**RE: BUDDHIST TEMPLE OF N.M. (K-19/D125)**  
**(224 Alcazar SE)**  
**ENGINEERS CERTIFICATION FOR CERTIFICATE OF OCCUPANCY**  
**ENGINEERS STAMP DATED 5/25/2001**  
**ENGINEERS CERTIFICATION DATED 5/30/2003**

**Re: Grading and Drainage Plan for Buddhist Temple of New Mexico,  
(K19/D125), Engineer stamp dated 3/26/01.**

A PROPOSED DRAINAGE PLAN
FOR
BUDDHIST TEMPLE OF NEW MEXICO
(ALCAZAR STREET, S.E.)
ALBUQUERQUE, NEW MEXICO
JANUARY, 2000

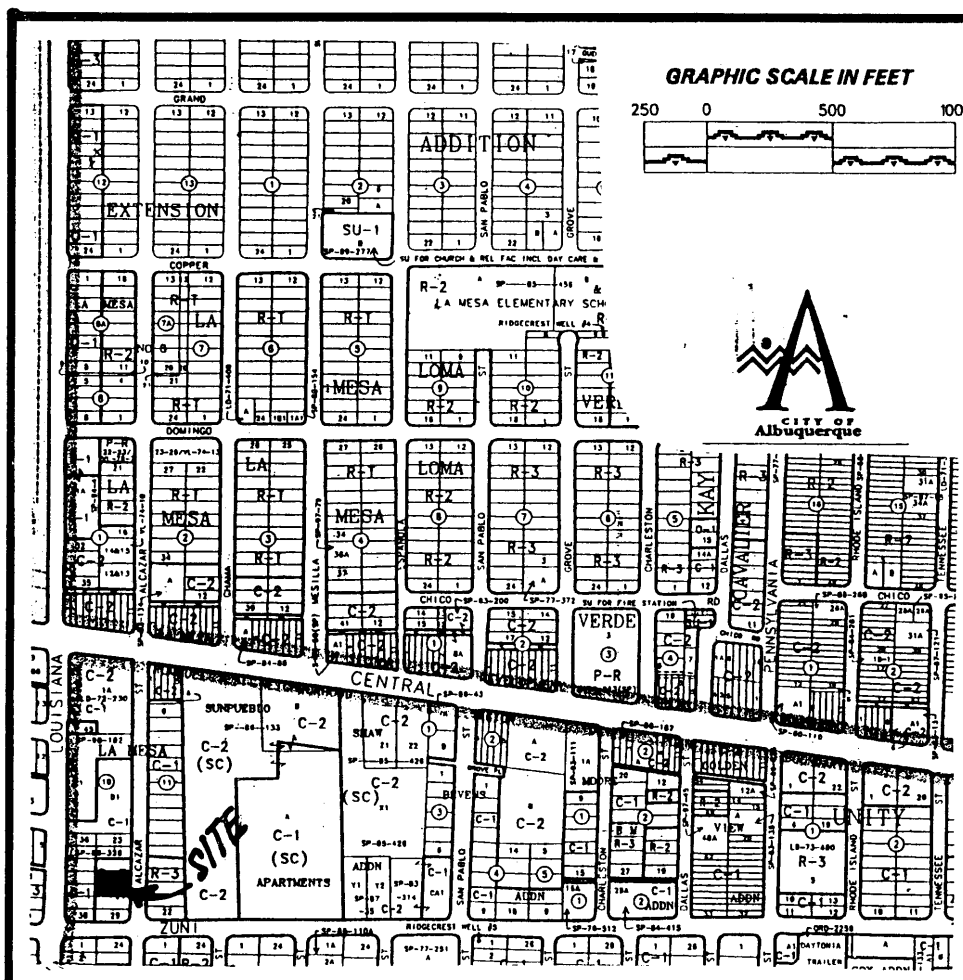
1. The plan needs to show top and bottom proposed grades for all retaining walls.
2. The drainage information narrative needs to indicate that a floodplain exists in Louisiana Blvd., and that that floodplain has not been restudied since storm drains have been constructed in Alcazar St.
3. Show existing elevations for curb and gutter on Louisiana, and for existing driveways at property line.
